EPC STORMWATER REVIEW COMMENTS
IN ORANGE BOXES WITH BLACK TEXT

OVERLOOK AT HOMESTEAD

PRELIMINARY PLAN

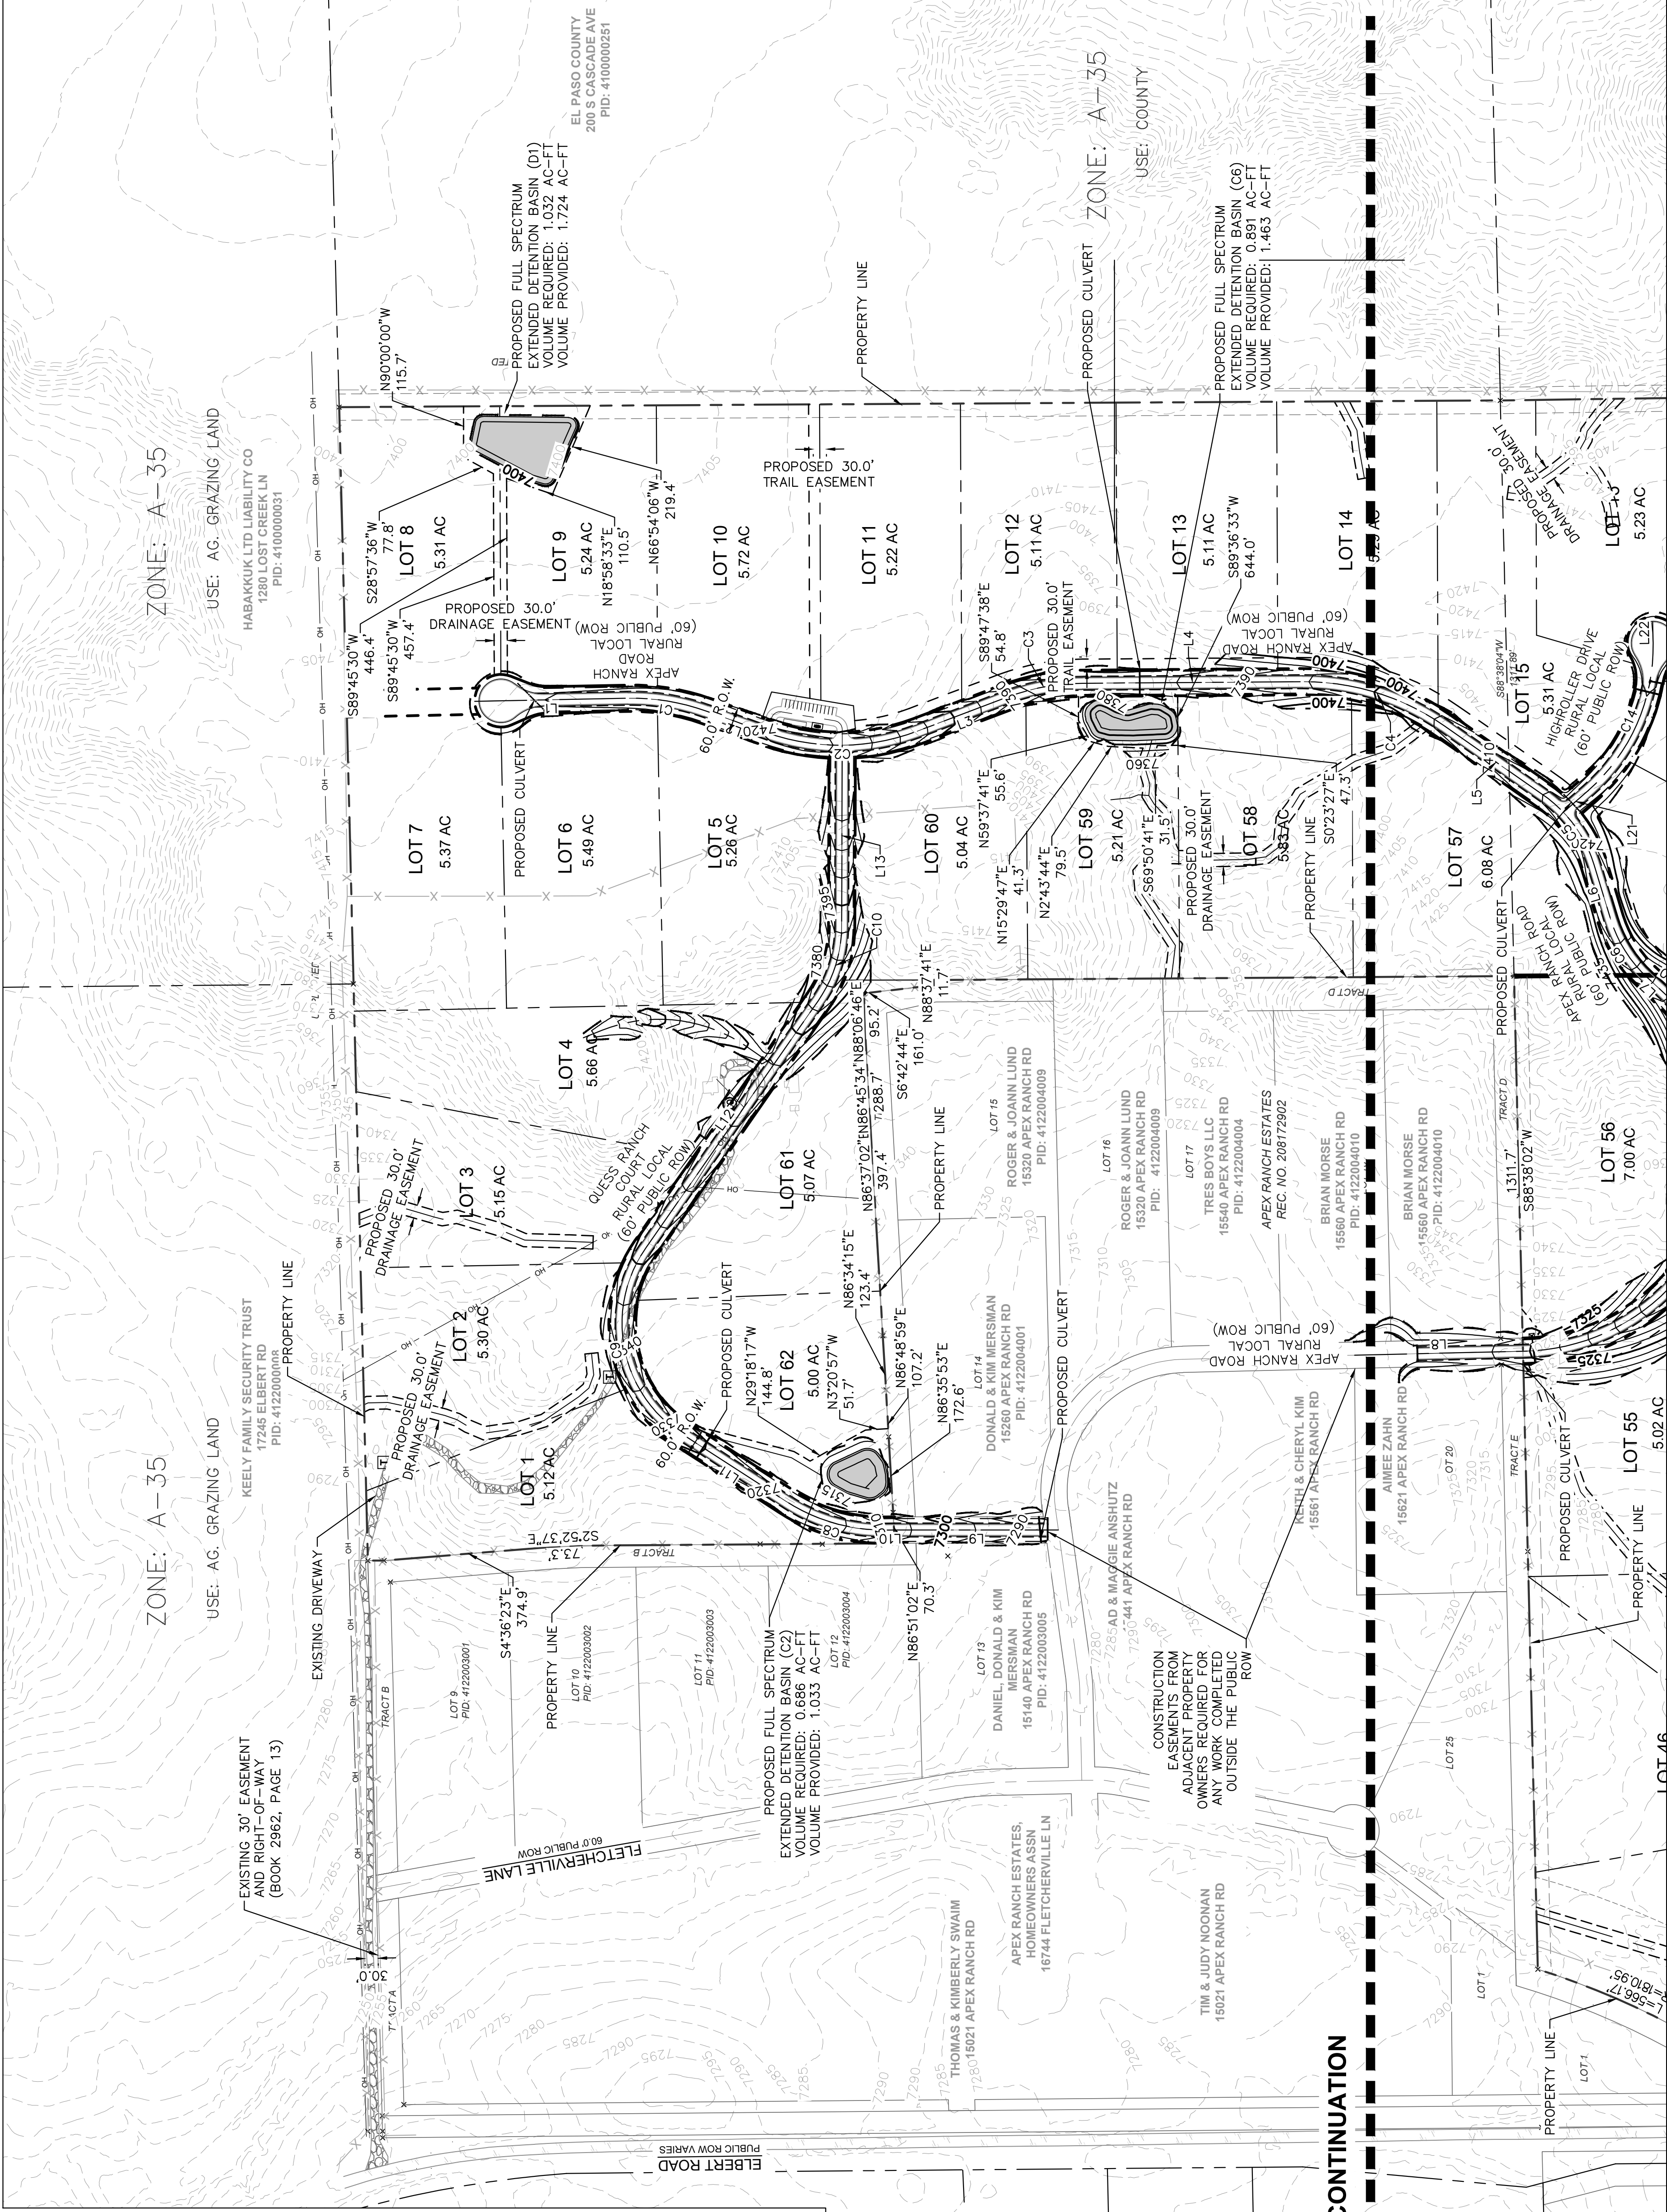
Add the approximate length of all street centerlines, centerline radii and approximate grades. The data may be placed in a data table.

Add ROW widths, public or private to all proposed roads depicted

provide distance and bearing of the proposed drainage easements throughout the plan

Label the contours, missing elevations

include easement width

PRELIMINARY GRADING PLAN NORTH

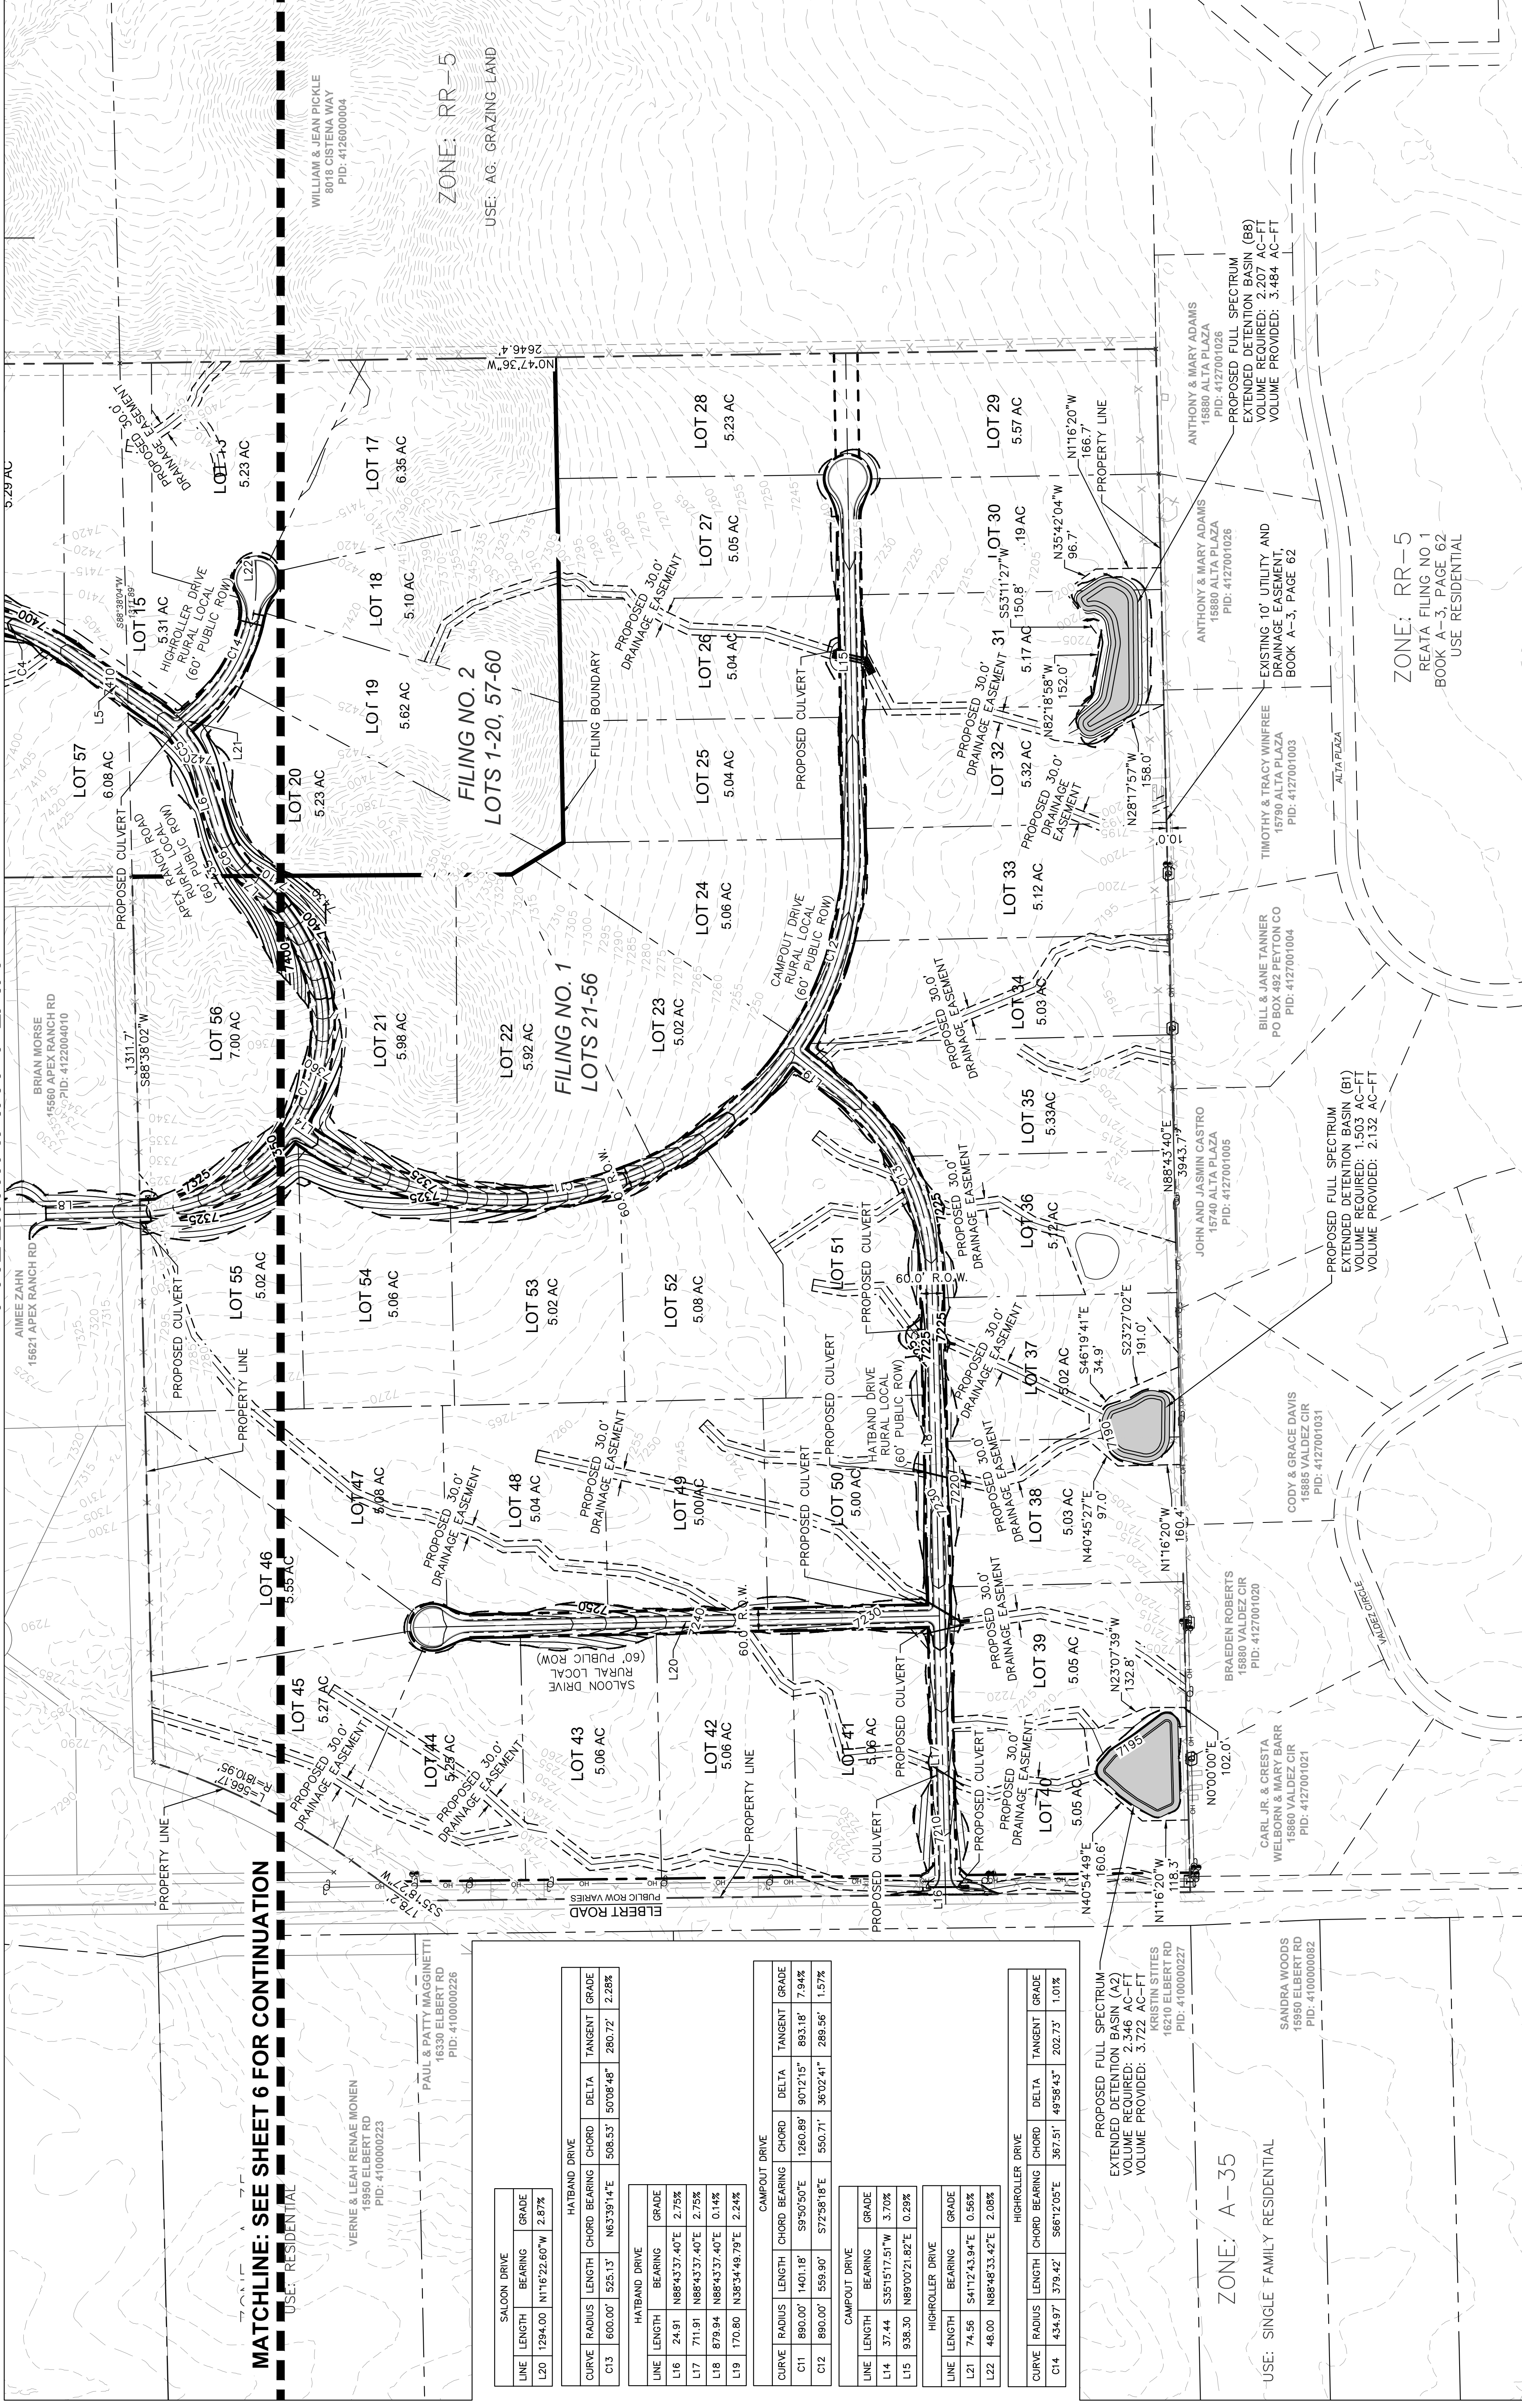
be aware that construction easements from the adjacent property owner will be required for any work outside the ROW.

please relocate the text to show the grading proposed for the roadway
